**State Environmental Planning Policy (Transport and Infrastructure) 2021
State Significant Development Application - SSD-66826207-Mod 1
405 Pacific Highway, 5 Falcon Street & 8 Alexander Street Crows Nest
Request for additional information**

27 June 2025

SHORING PILE SCHEDULE					
MARK	DIA.	VERT. BARS	TIES	CONC GRADE	COVER (mm)
P1	600	8N28	N16-175	50 MPa	60
P2	600	8N32	N16-150	50 MPa	60
P3	600	6N32	N16-125	50 MPa	60
P4	750	8N28	N16-150	50 MPa	60

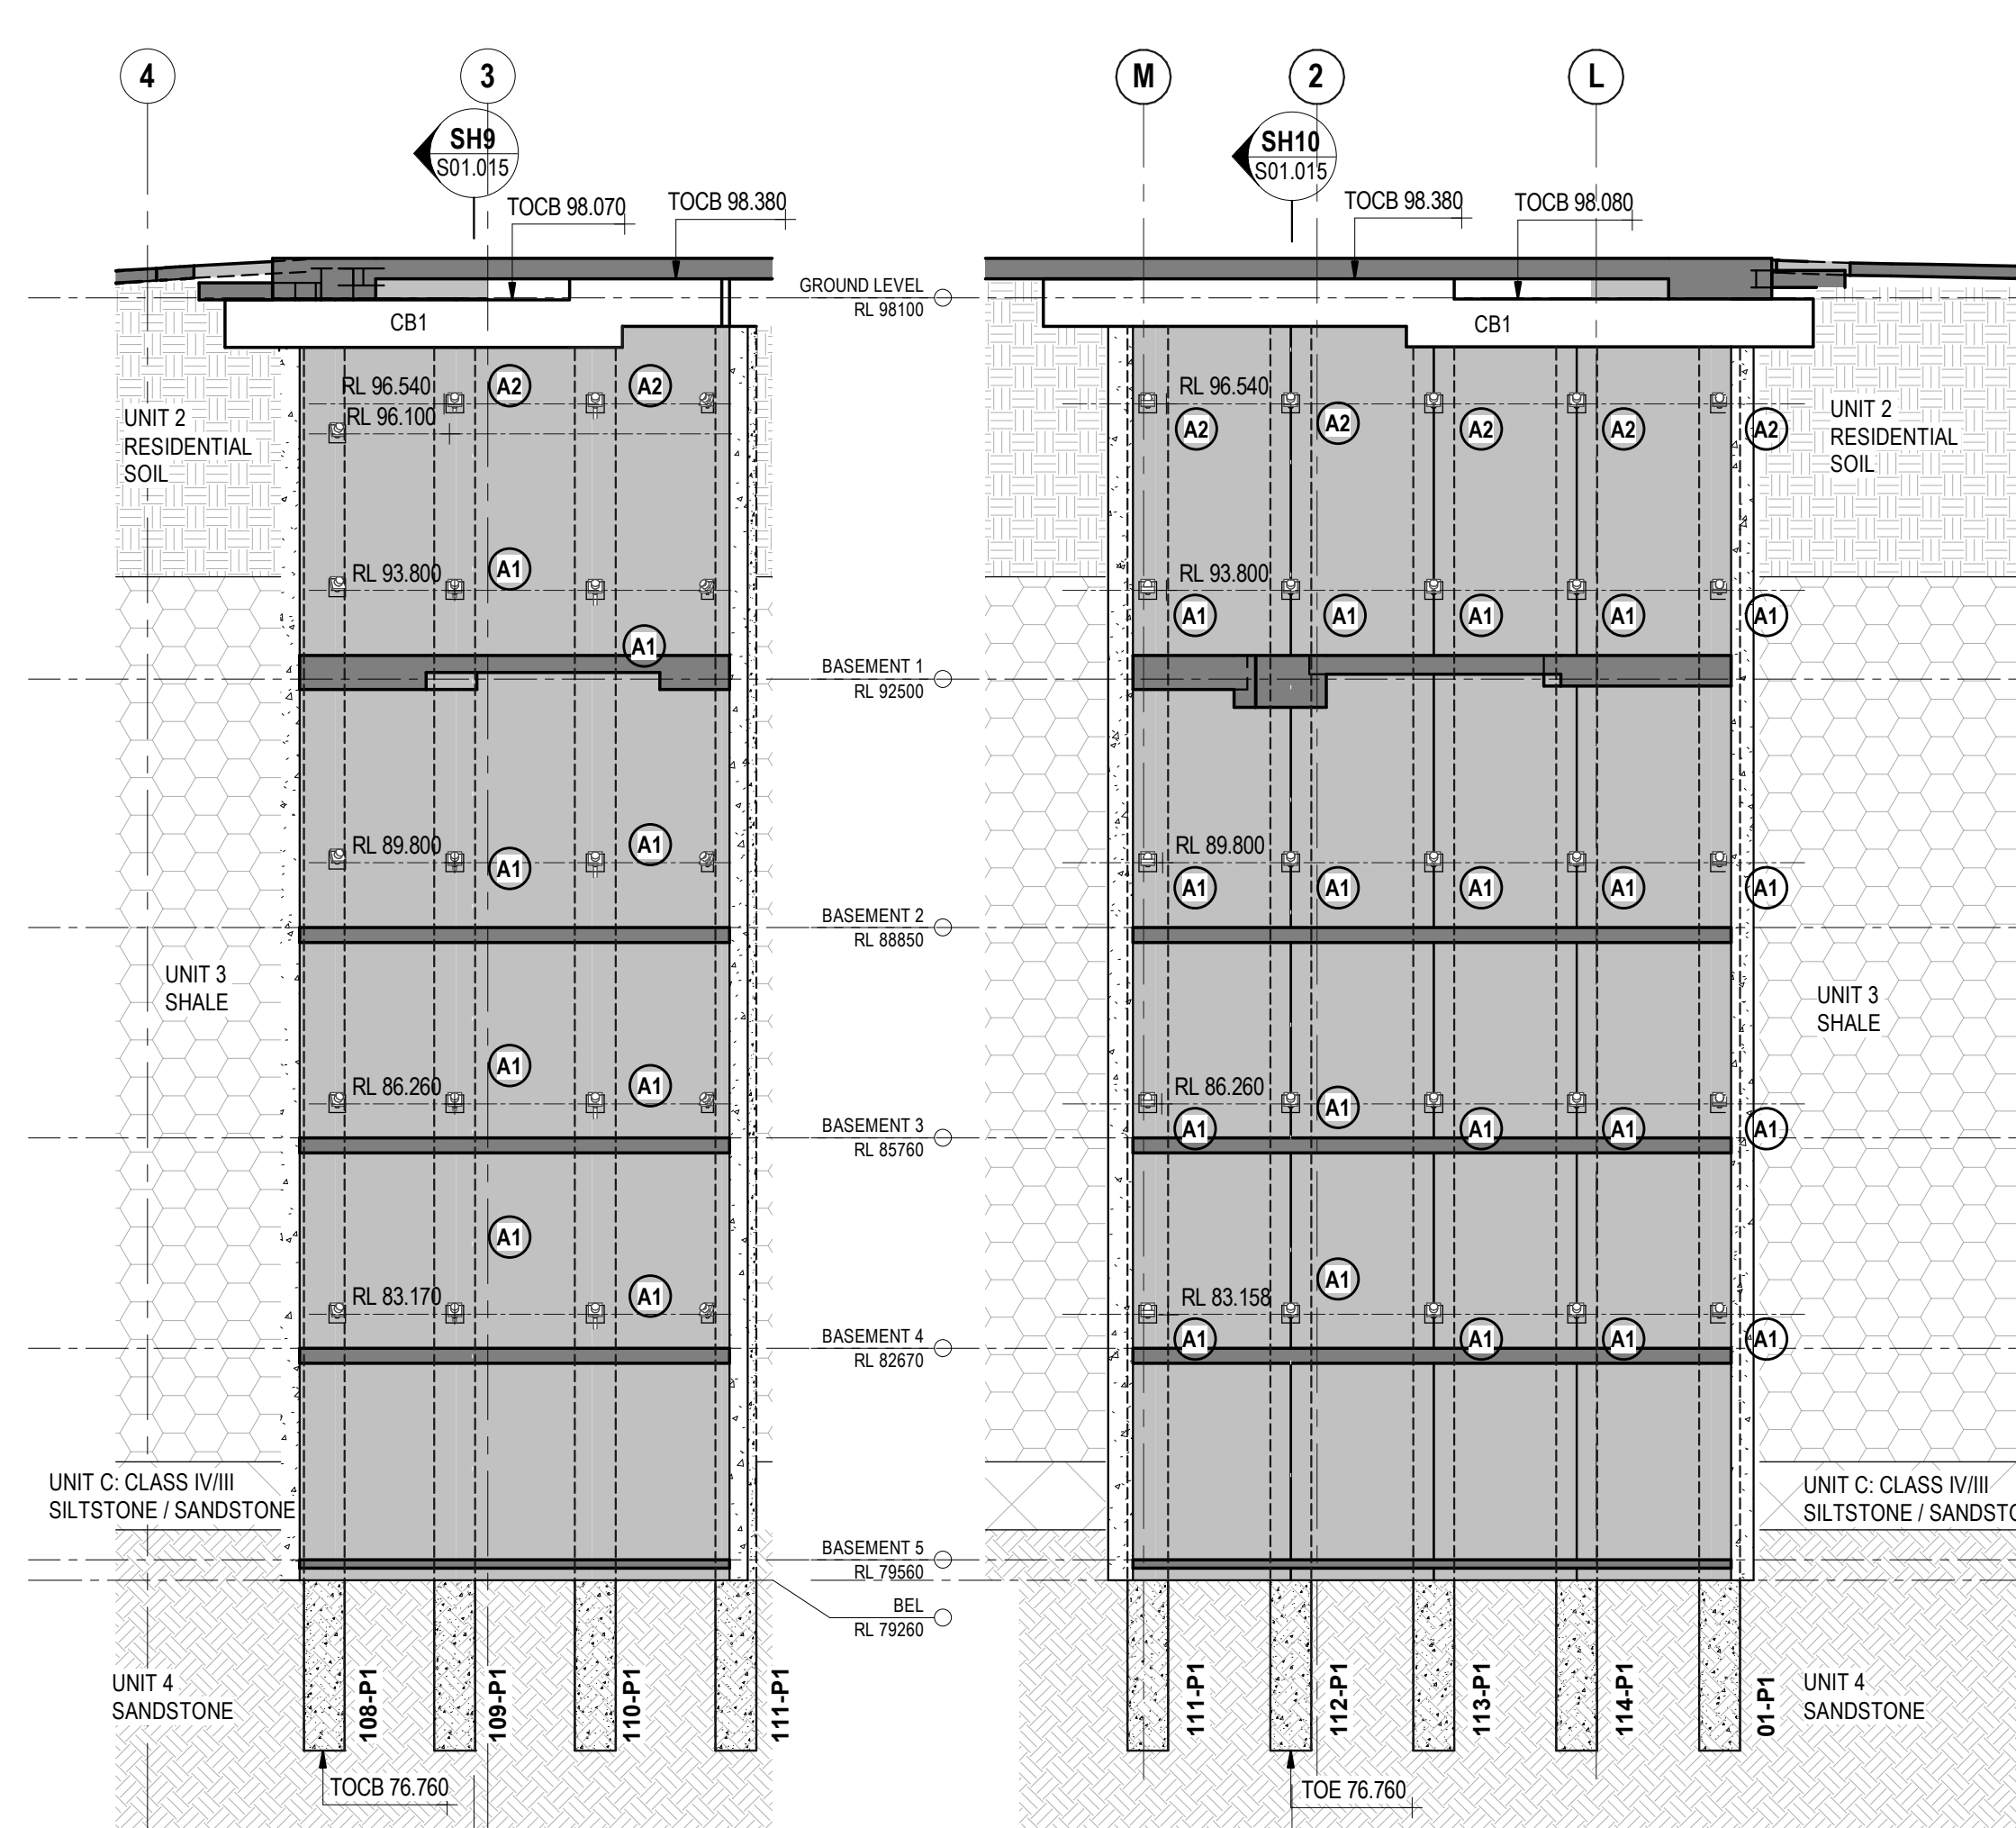
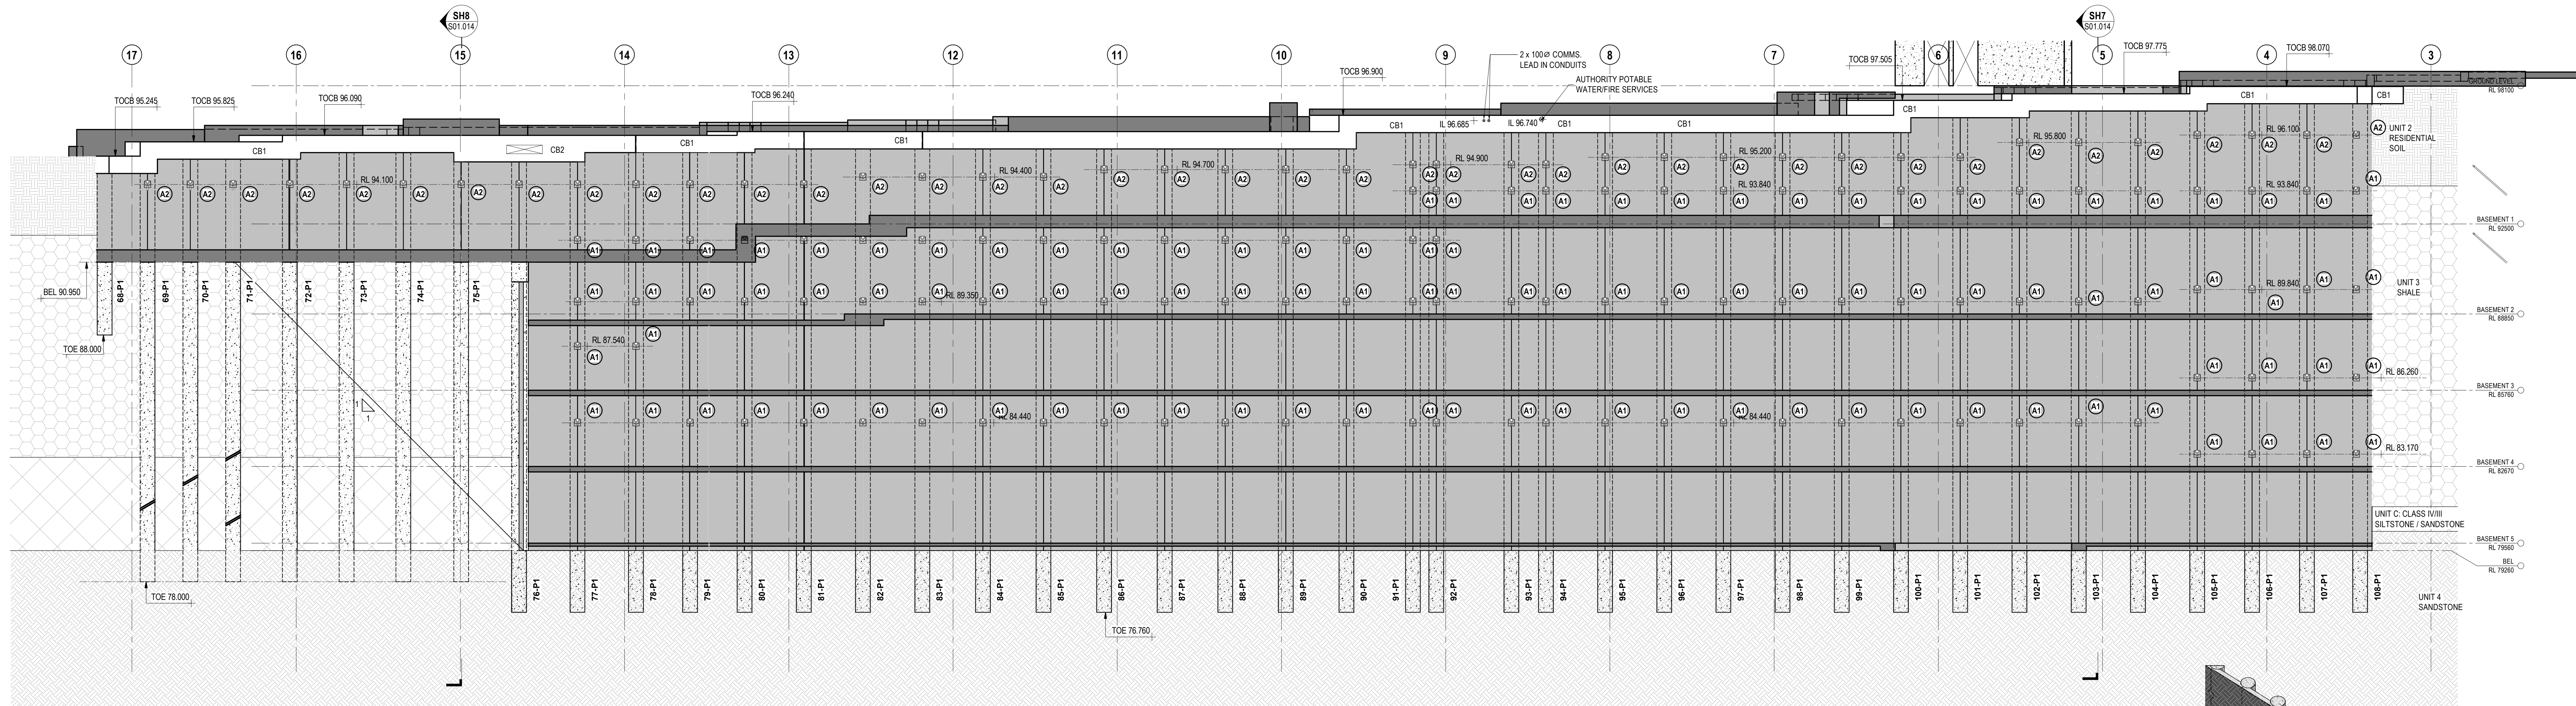
- g) The proposed shoring pile toe level is RL76.760 which is around 3m above the 1st reserve. Please provide an impact assessment of the proposed shoring wall design.
- h) Shoring wall elevation drawings show that P1 to P4 piles but only pile type P1 is listed in Pile Toe Schedule table on drawing S01.001 Rev 05.
- i) Section SH2 shows that anchors to be installed would be below the shoring pile toe level which is in closer proximity to the 1st reserve.
